**Our ref:** 25\_33131\_P

**Your ref:** H09-0796-25

**Site Location:** Land East of Forest Way Holbeach  
Spalding Lincolnshire

**Summary of Proposal:** Proposed Erection  
of 2 Bungalows

PROPOSED SITE PLAN
scale 1:200

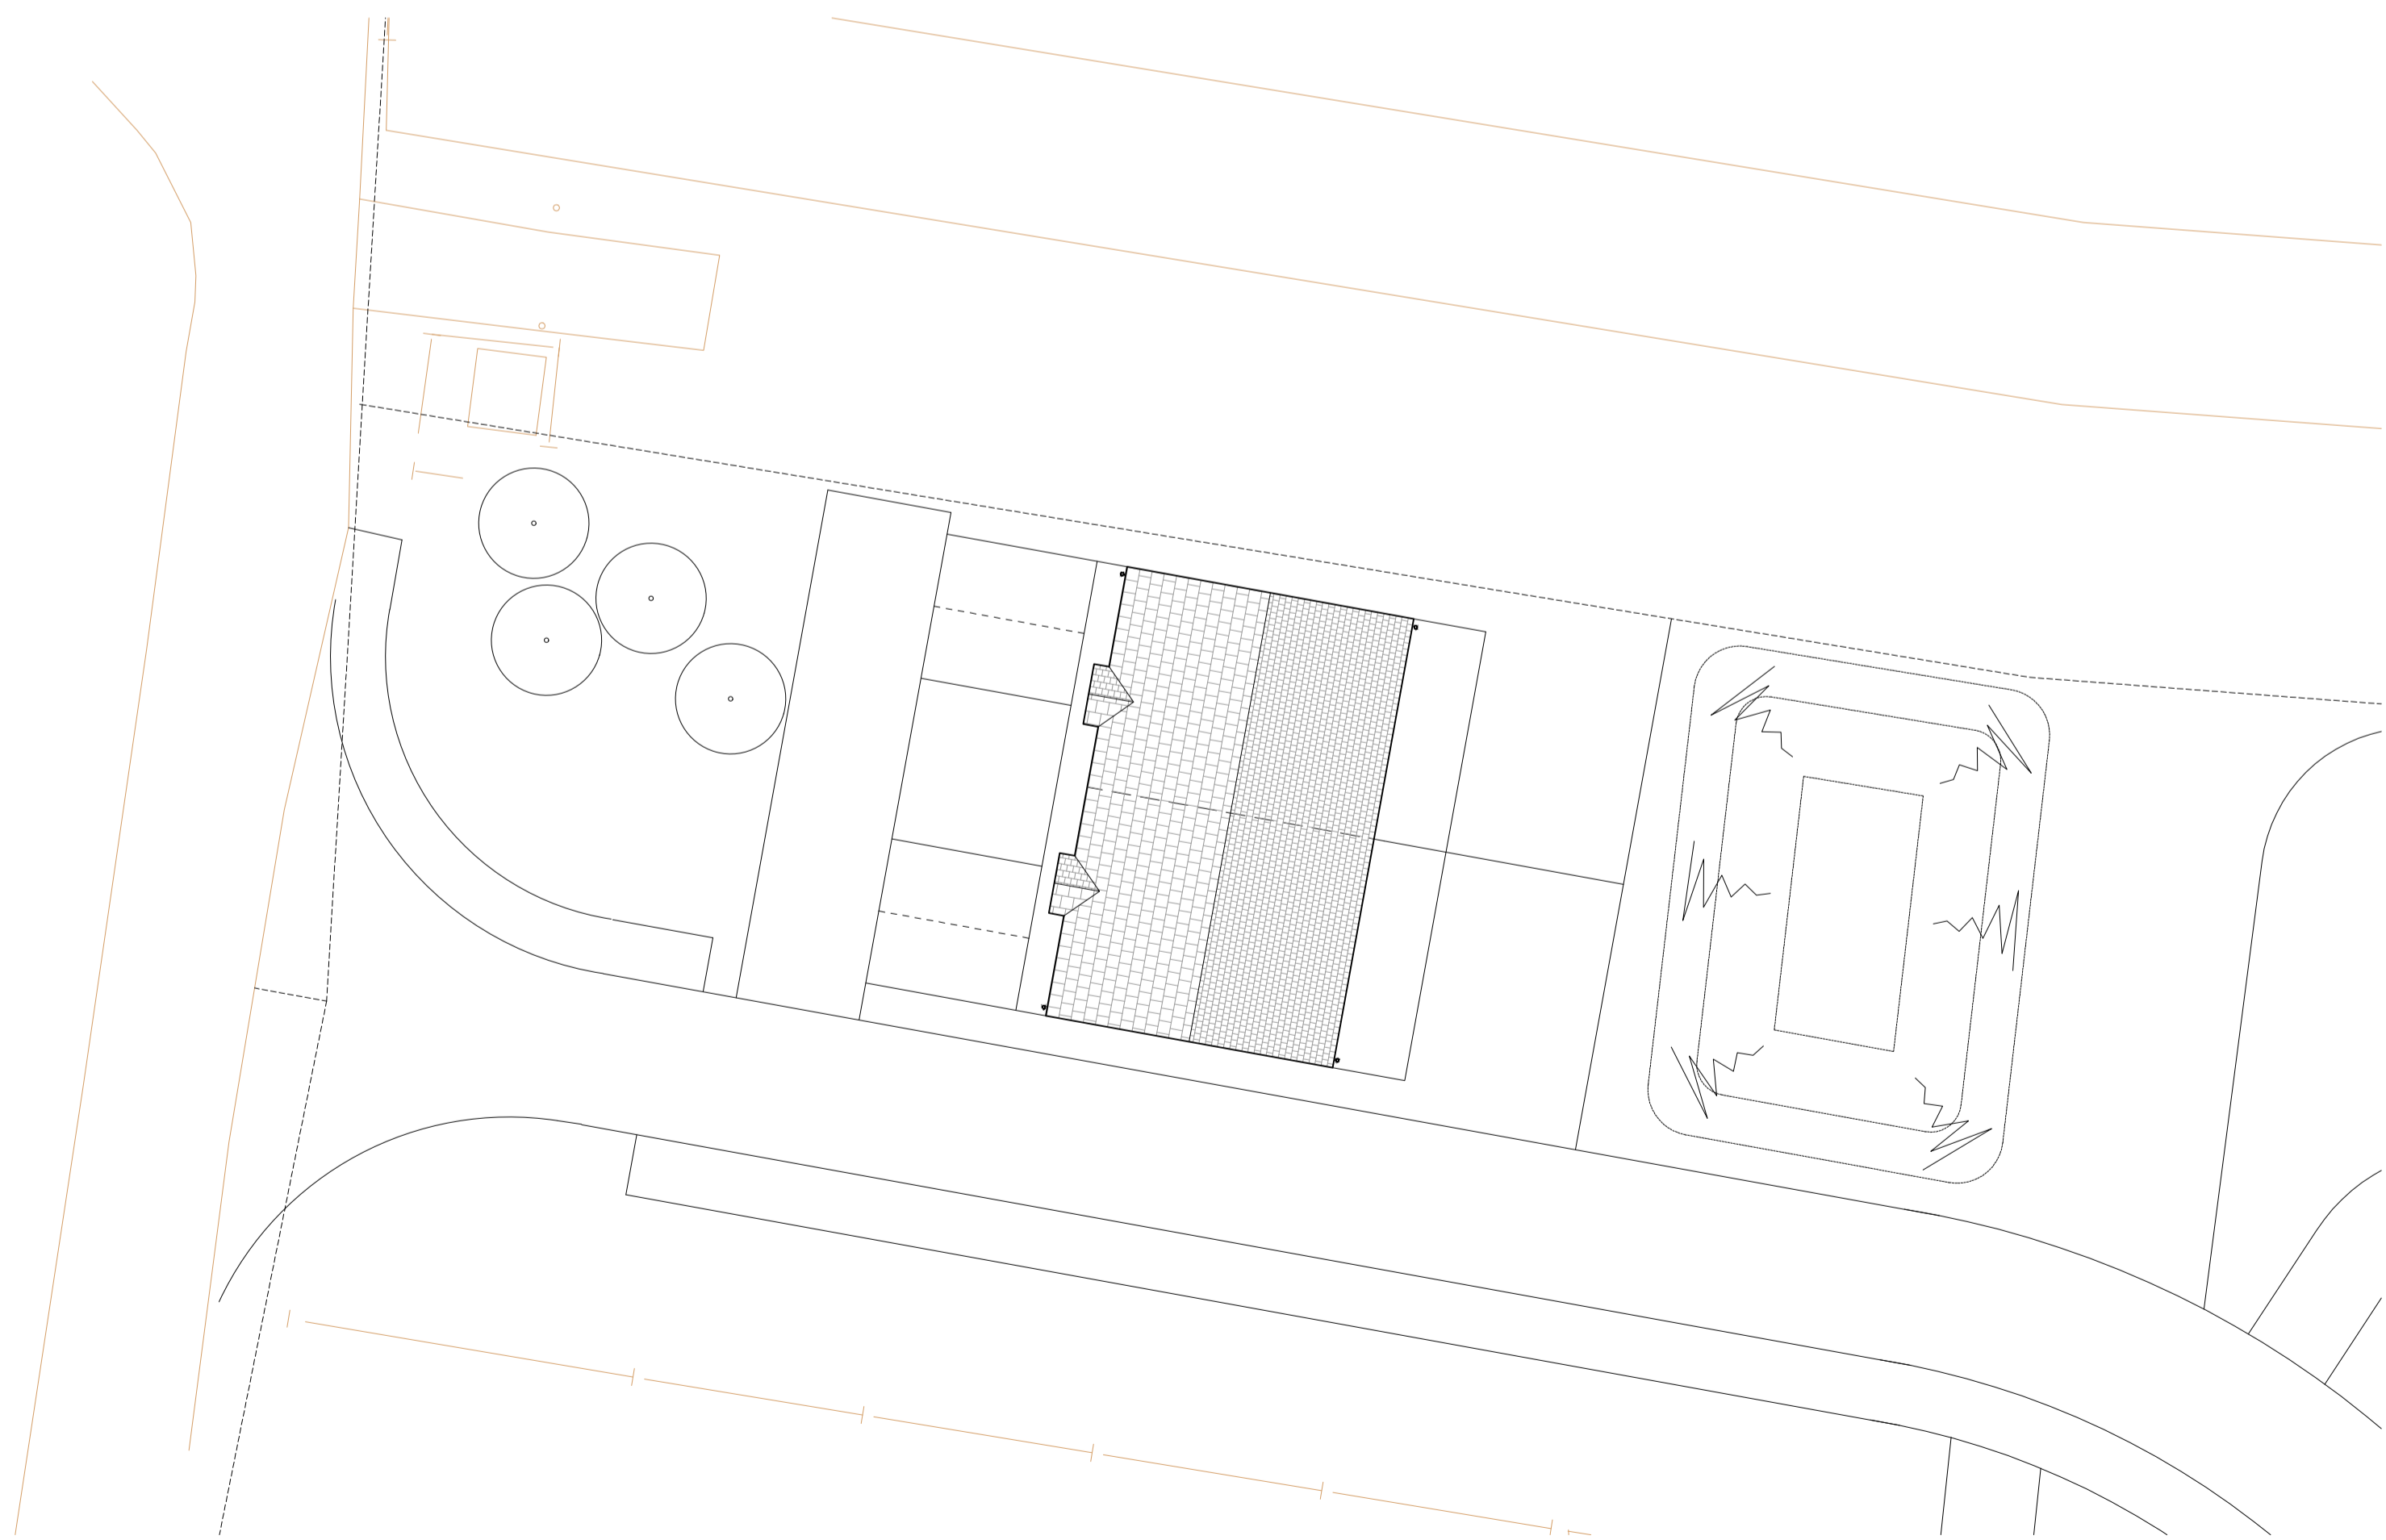
The applicant has indicated that they intend to dispose of surface water via infiltration, however I cannot see that the viability of this proposal has been evidenced. We recommend that ground investigation is carried out to determine infiltration potential, followed by testing in line with BRE Digest 365 if onsite material is considered favourable for infiltration.

If infiltration is not feasible at this site, following the drainage hierarchy we would expect the applicant to propose to discharge surface water to a watercourse. In this case, consent would be required under Byelaw 3. The Board recommend that any discharge is in line with the [National standards for sustainable drainage systems \(SuDS\)](#) published in June 2025. Further to the National Standards for SuDS, the Board's policy is to restrict discharges to 2l/s/ha or annual average flood flow rate (QBar or QMed), whichever is higher.

I note the presence of a Board Owned and Maintained watercourse (DRN197P3703 - F37 Holbeach New River) adjacent to the eastern site boundary. Whilst not currently proposed, should the applicant's proposals change to include works to alter the watercourse, or if works are proposed to alter the watercourse at any time in the future, consent would be required under the Land Drainage Act 1991 (and byelaw 4).

Whilst not currently proposed, should the applicant's proposals change to include works within 9 metres of the aforementioned Board Maintained watercourse, or if works within 9 metres of the watercourse are proposed at any time in the future, consent would be required under Byelaw 10.
